A585 Windy Harbour to Skippool Improvement Scheme

7.11 Environmental Statement Changes and Corrections Document

August 2019

Status	DEADLINE 2 SUBMISSION	Revision	1
Scale	1:2500 A3	Date	MAY 2019
Drawn By	J.NORMAN	Checked By	K.BURROWS
Approved By	N.HENDERSON		
PINS No.	TR010035	FIGURE	11.4
Drawing number	HE548643-ARC-EGN-SZ_ZZ_000-DR-LE-30

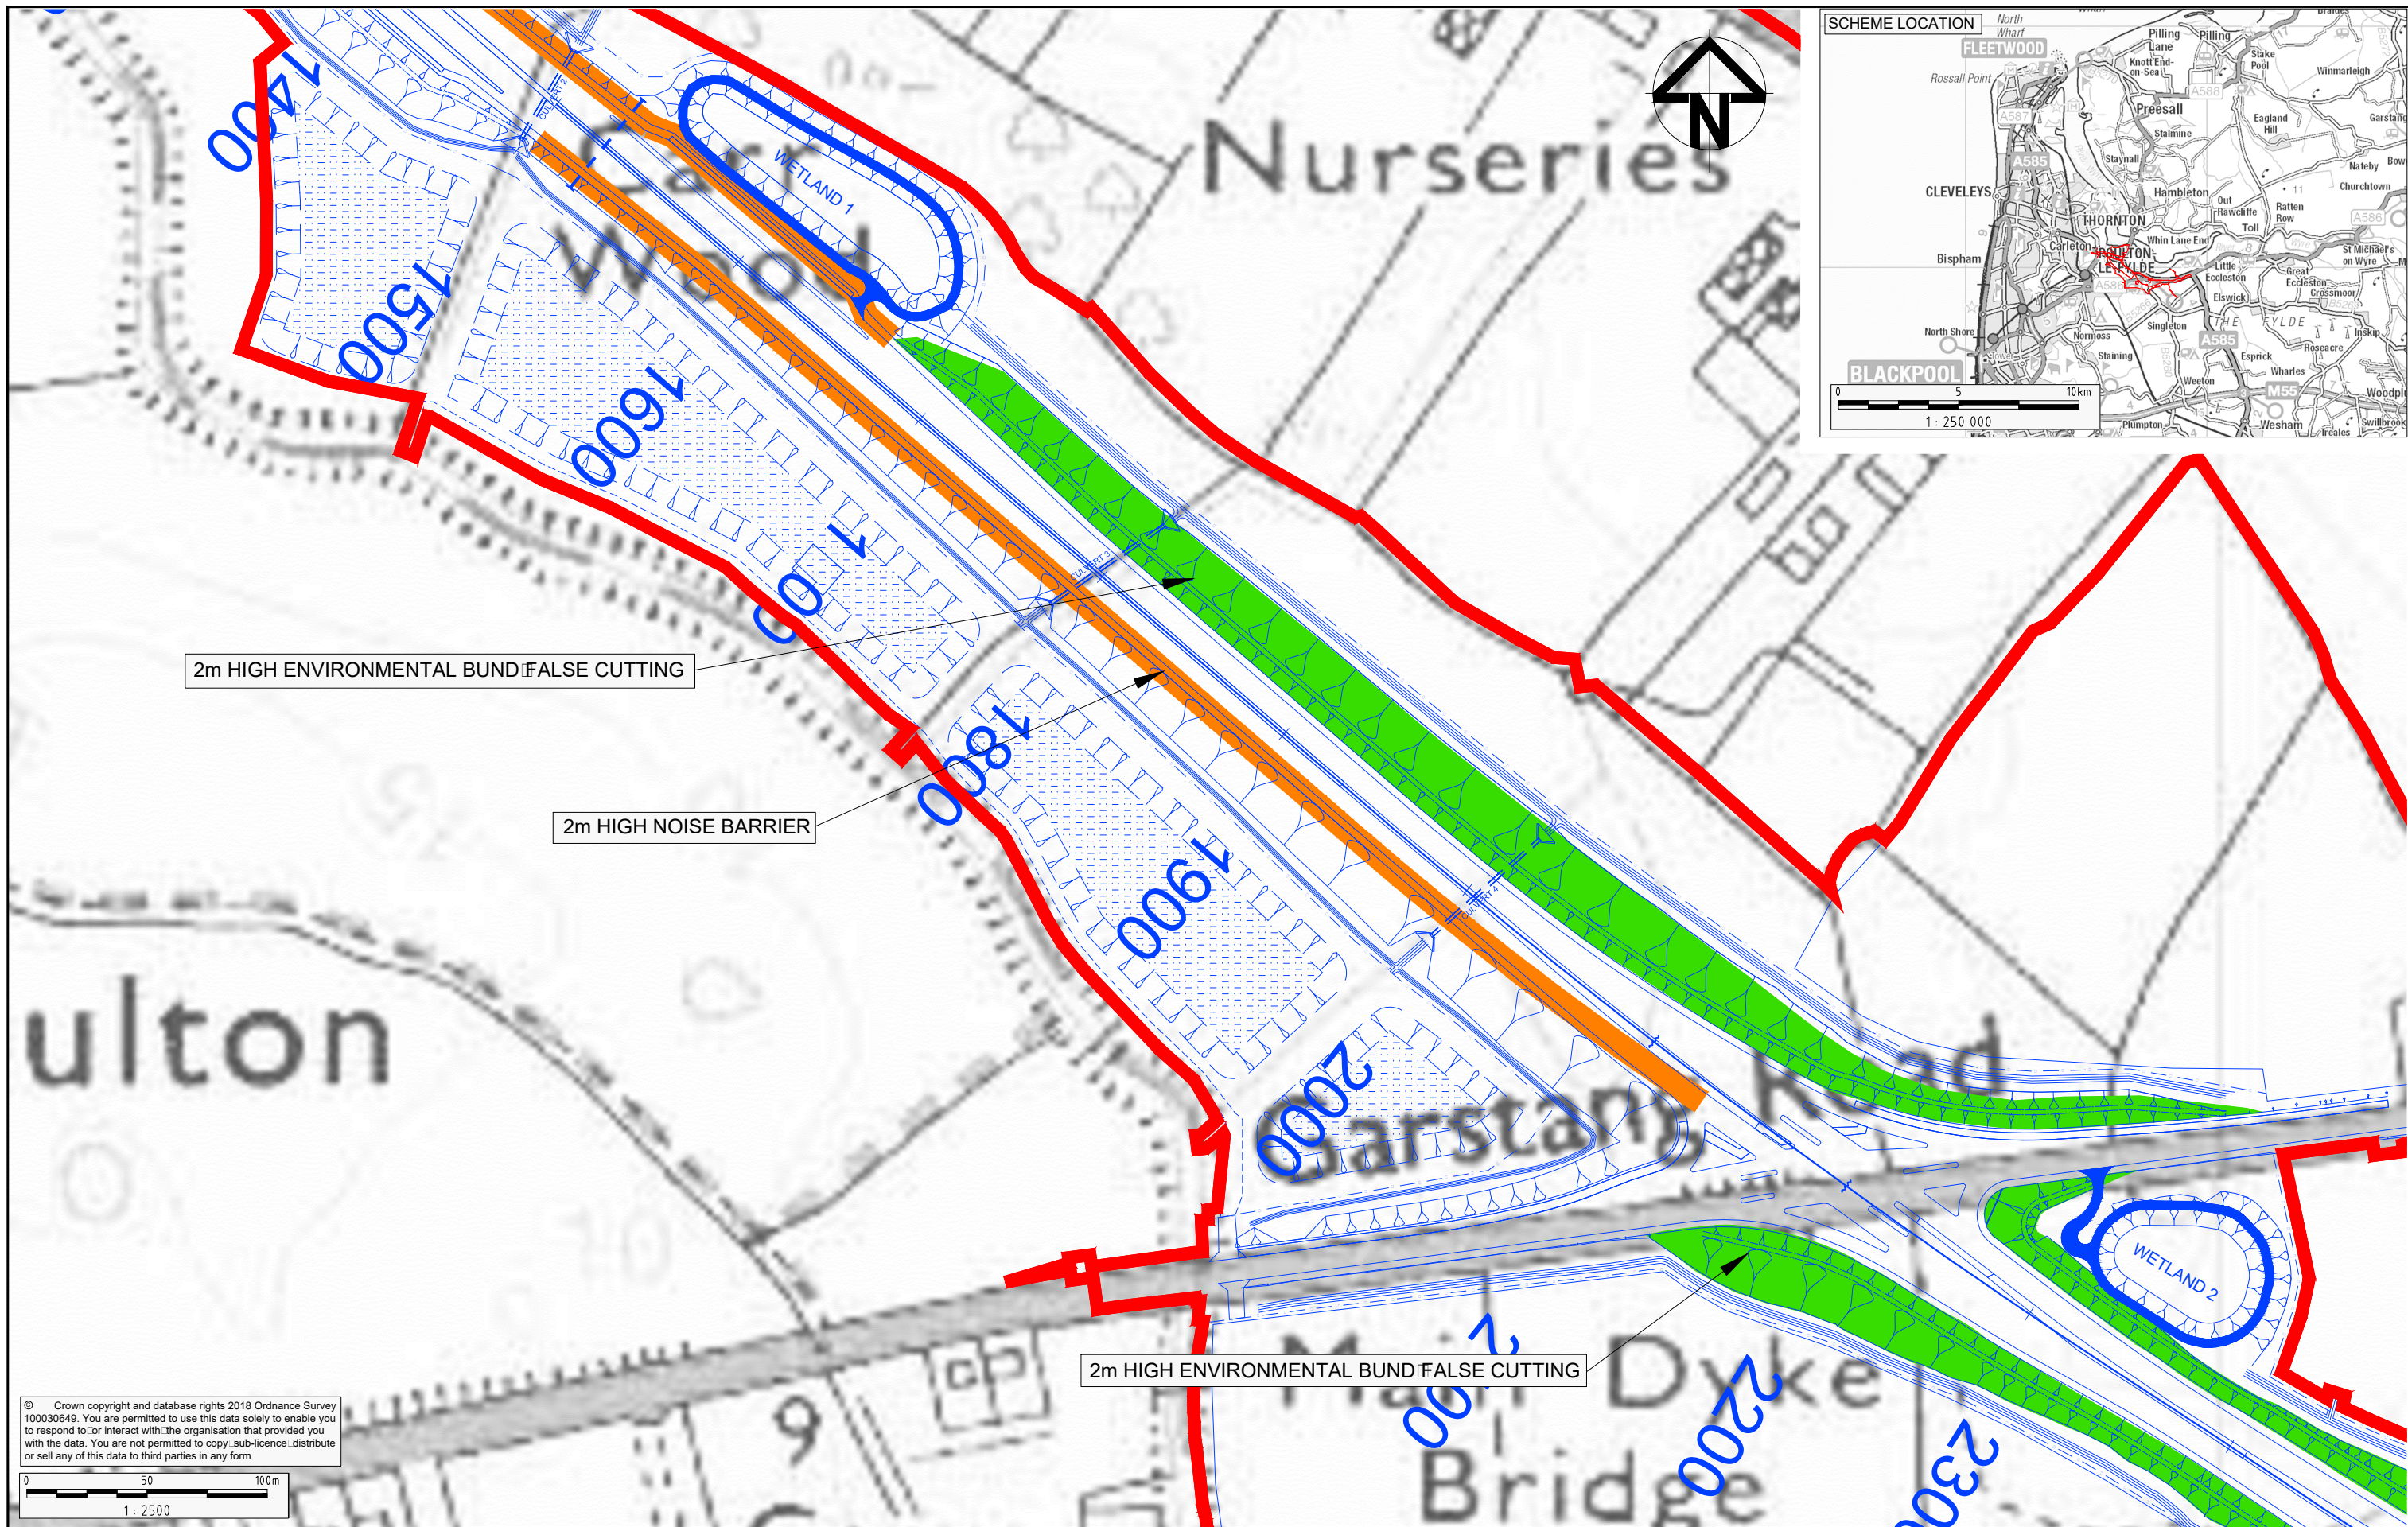
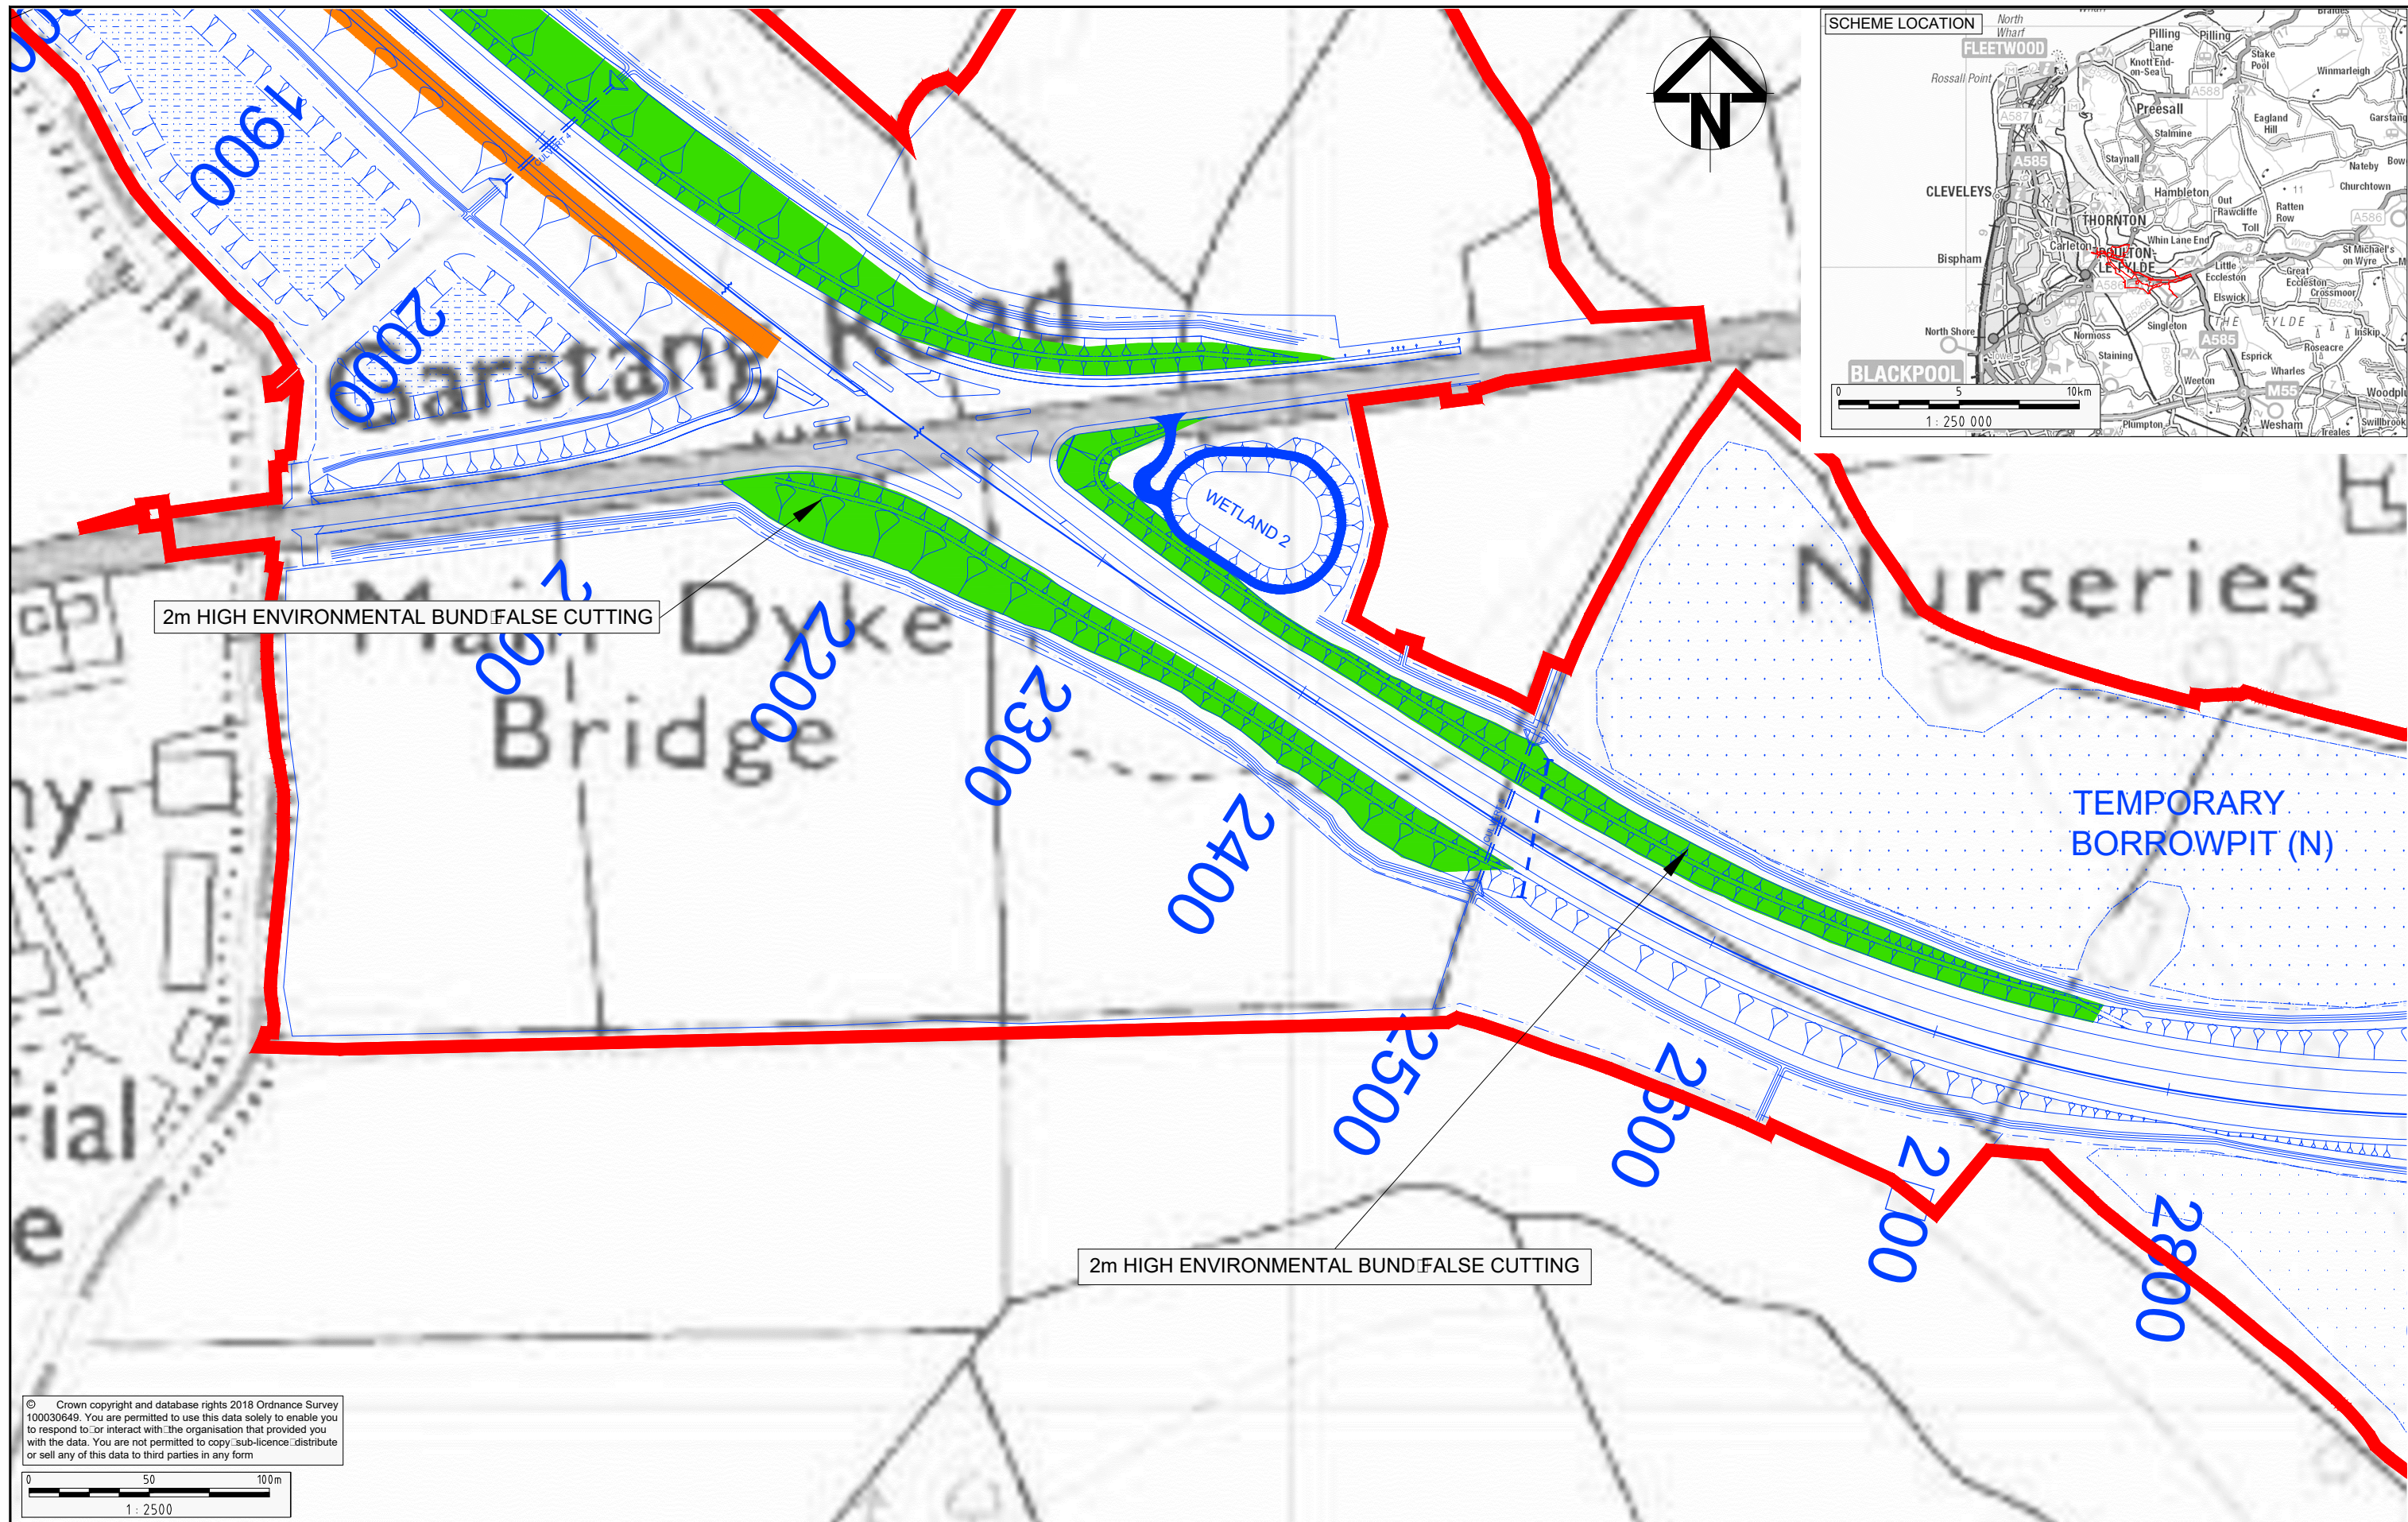
Document Reference Number	Document Name	Amendment Required	Reason
			TR010035/APP/7.10).
6.11	ES Chapter 11: Noise and Vibration	Update to Figure 11.4: Noise and Vibration – Noise Mitigation within the Study Area presented at Appendix D to show heights and locations of earth mounds and acoustic fencing at a larger scale.	Requested by the Inspector within the first round of written questions (document reference TR010035/APP/7.10).
